CITY OF PORTLAND BUILDING PERMIT

PERMIT ID: 2013-00172

has permission to **Install laundry chute from 2nd thru 6th to first floor laundry room.**
provided that the person or persons, firm or corporation accepting this permit shall comply with all of the provisions of the Statutes of Maine and of the Ordinances of the City of Portland regulating the construction, maintenance and use of the buildings and structures, and of the application on file in the department.

Jeanie Bourke - Re: embassy laundry chute

Drawing Title:
LINEN CHUTE DETAILS

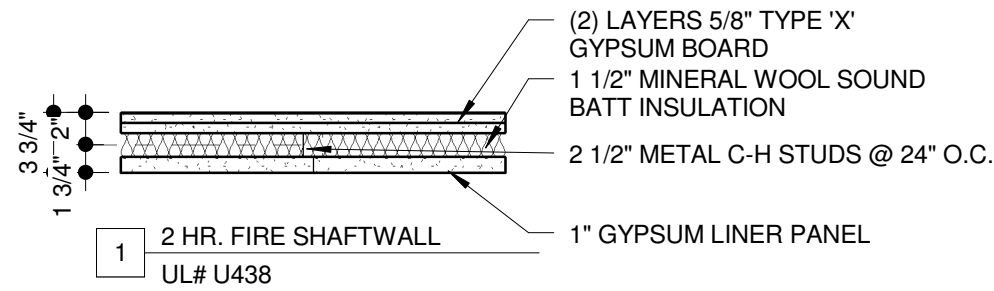
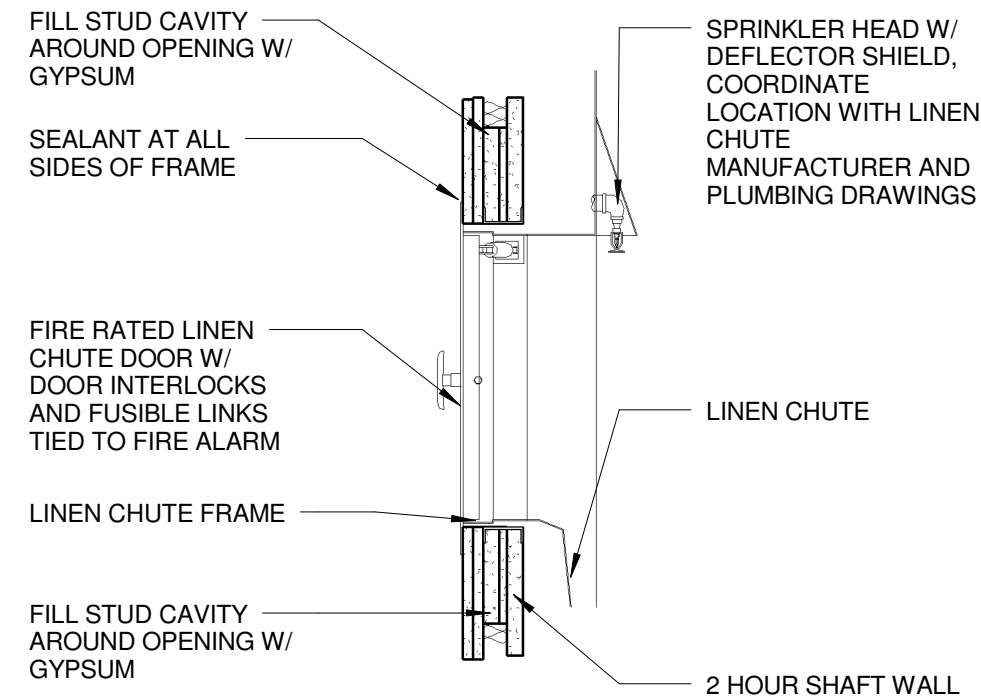
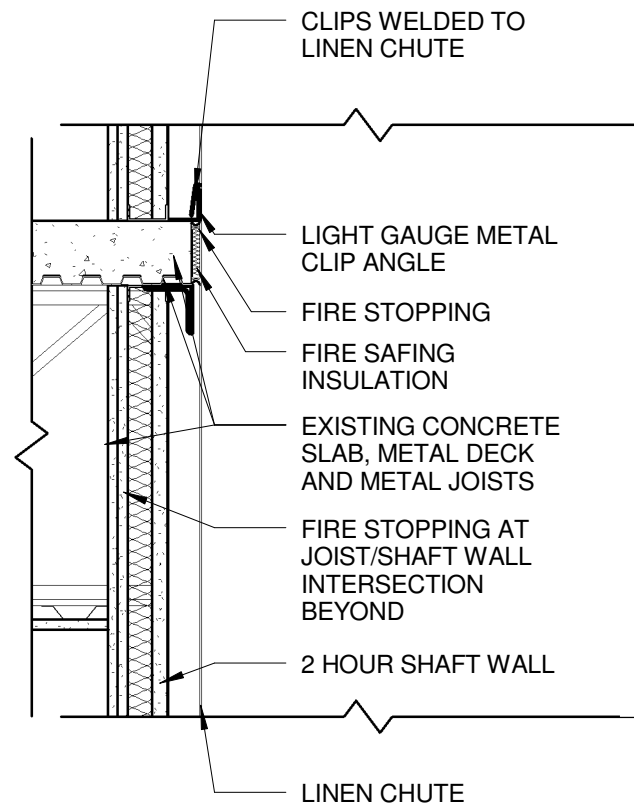
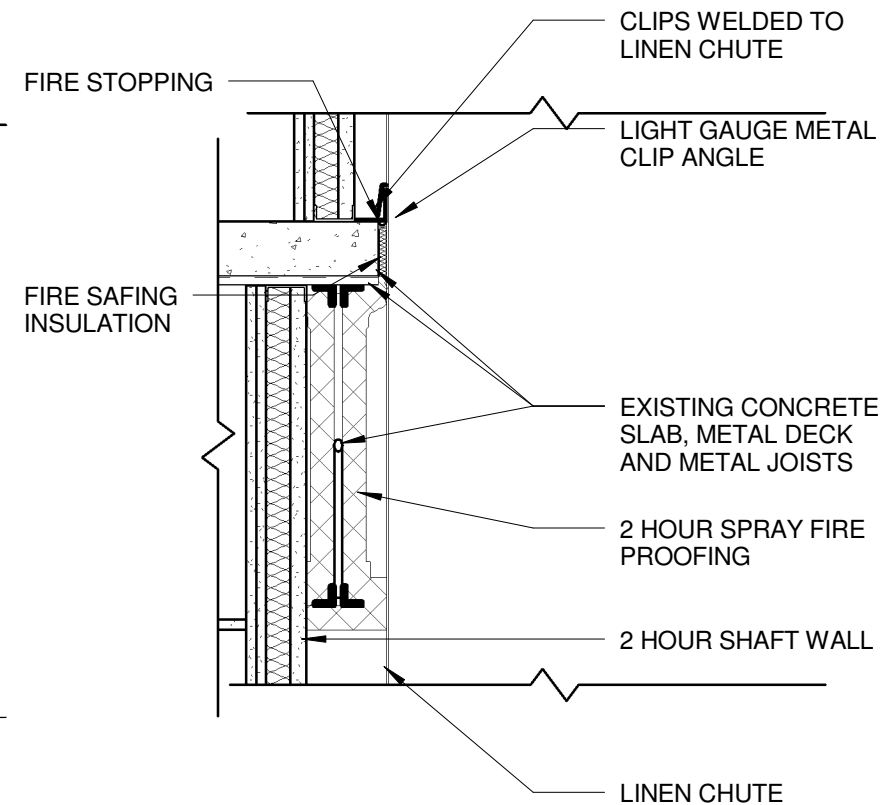
I have another question, do you know if the laundry chute access rooms and termination room are rated and have protected openings per IBC Sec. 708.13.3 & 4? This is a requirement in addition to the rated chute access doors.

The access rooms and termination rooms meet this requirement and the protected openings have closures on them. They are separated from corridors.
